Application for Planning Permission for Works or Extension to a Dwelling

Development: Erection of a garden room.
Location: The Coach House Norton Lane Norton PO20 3NH

PROJECT:	The Coach House Norton Lane Chichester PO20 3NH
DRAWING:	02 - Existing and Proposed Site Plan
SCALE:	1:500
REV:	
DATE:	01/09/25

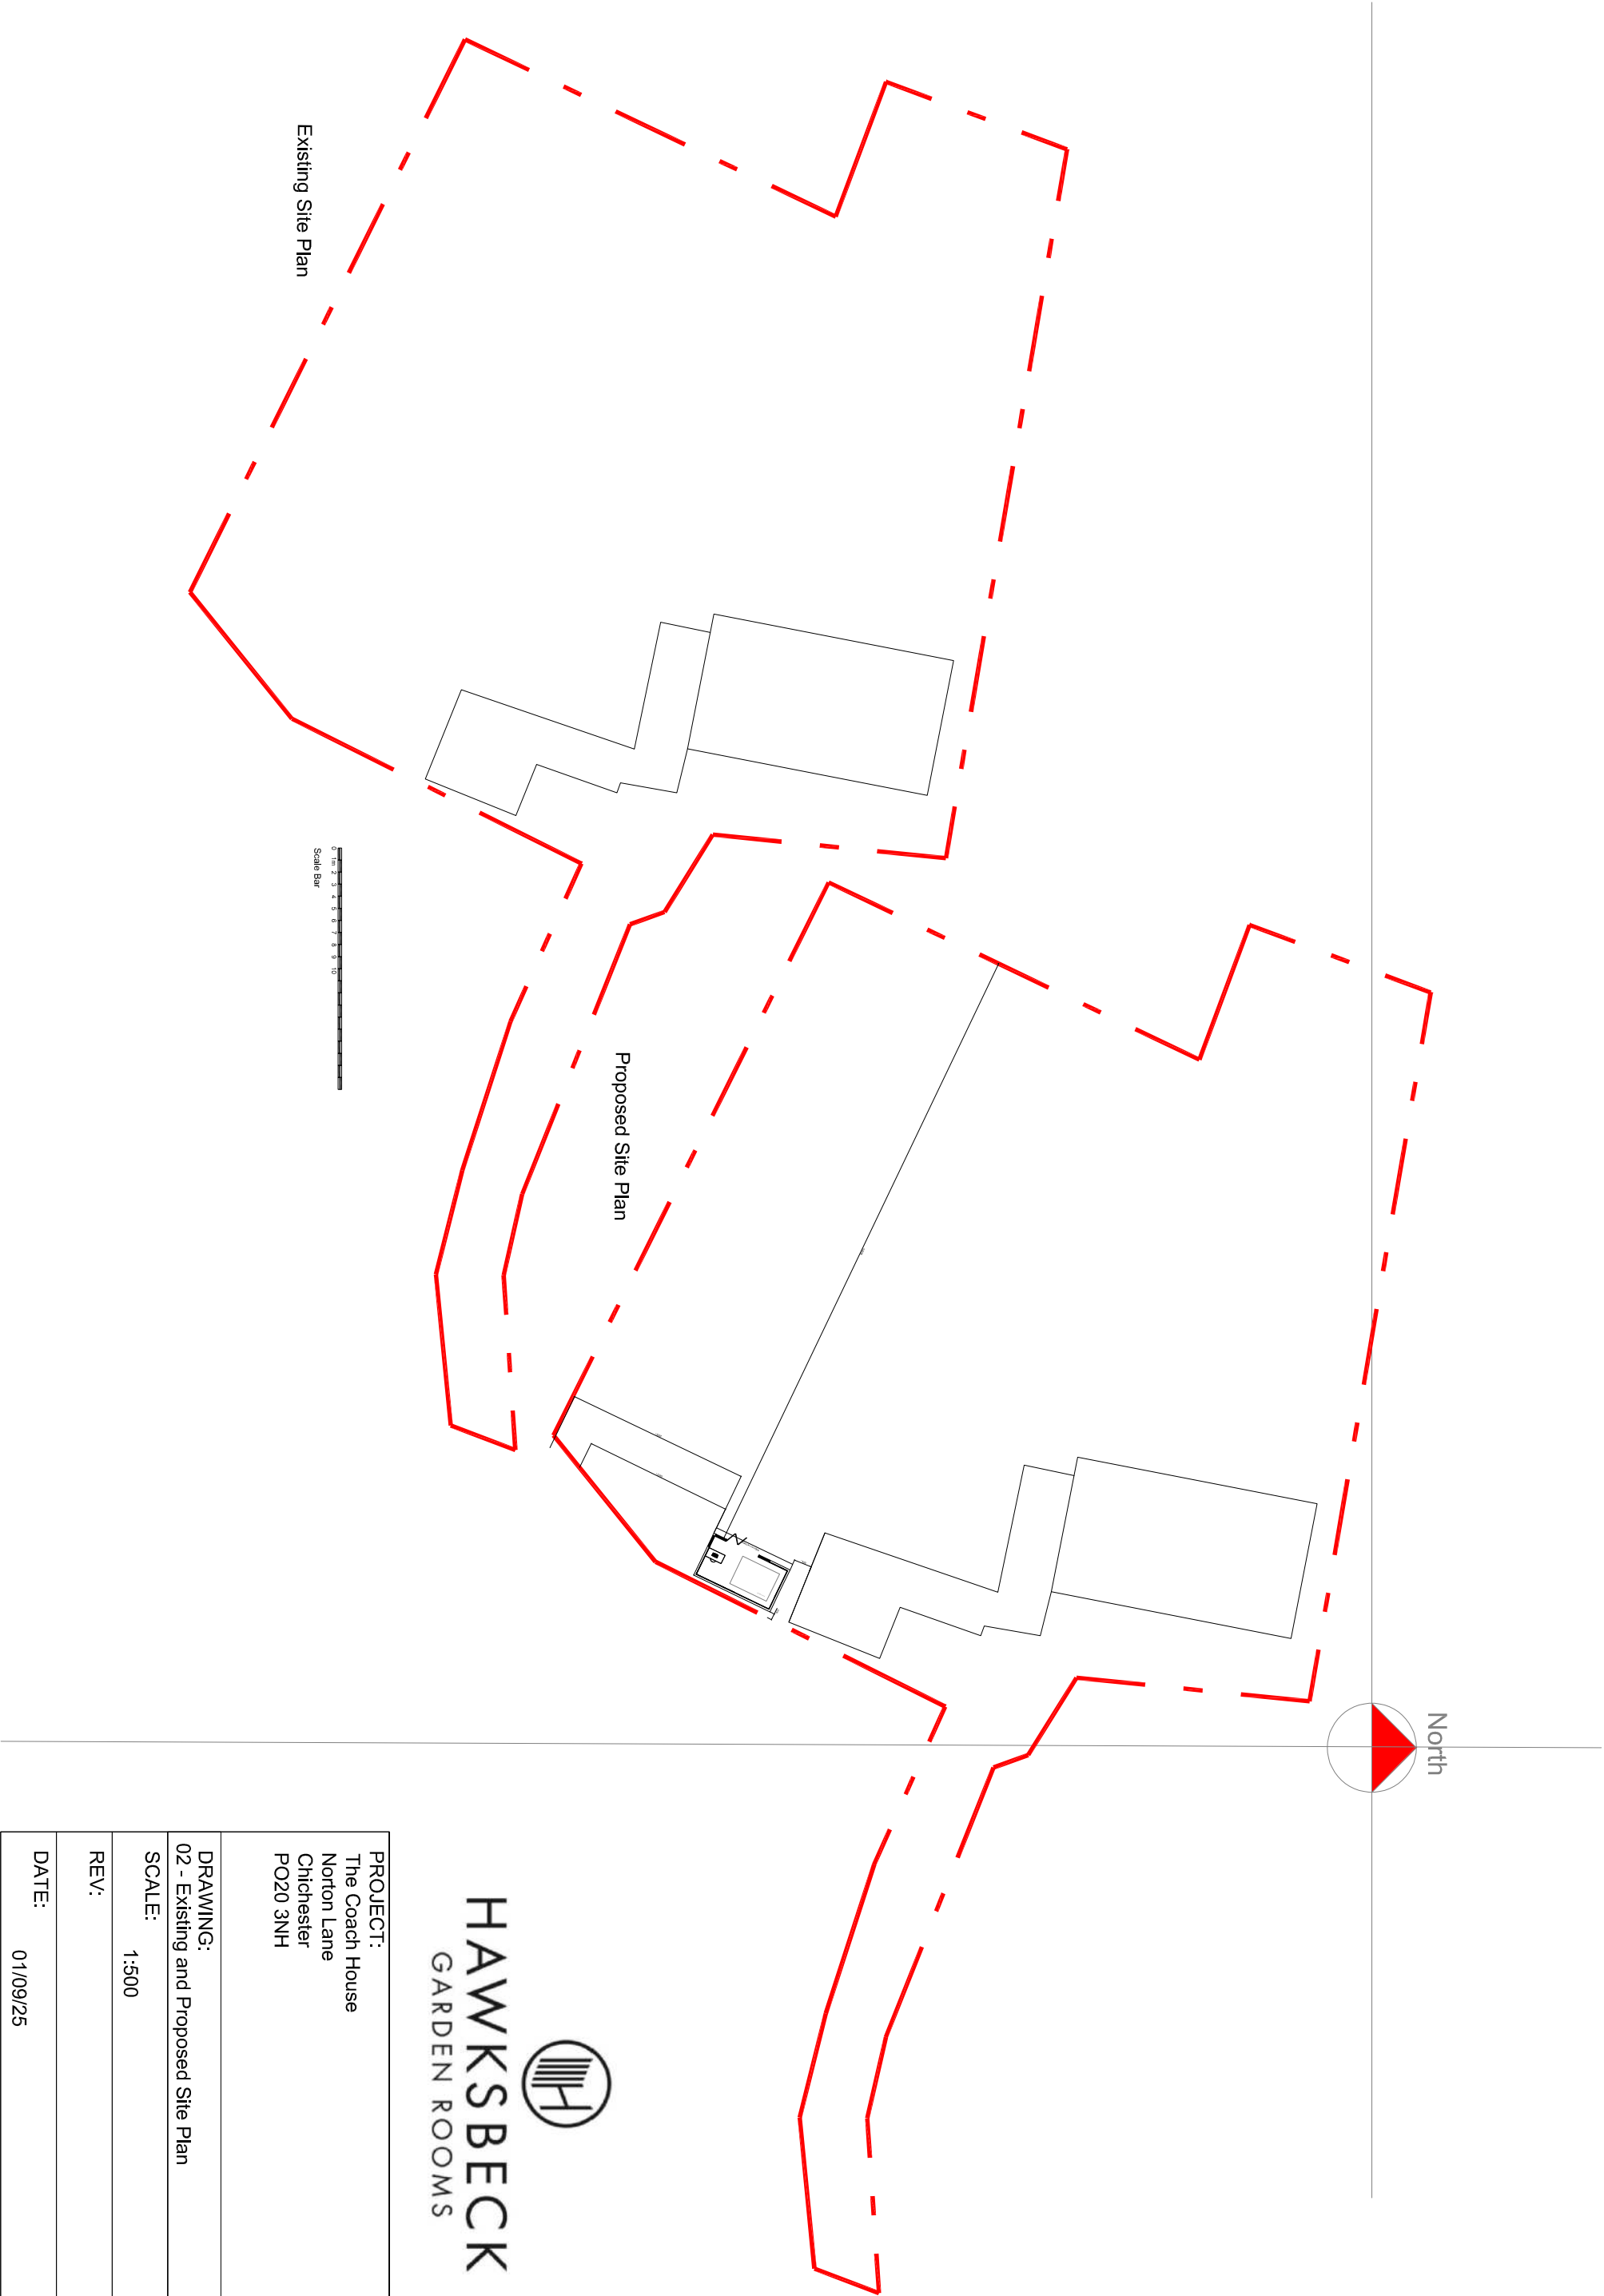
You are required to have dimensions from the proposed extension(s) to all site boundaries. Please amend.
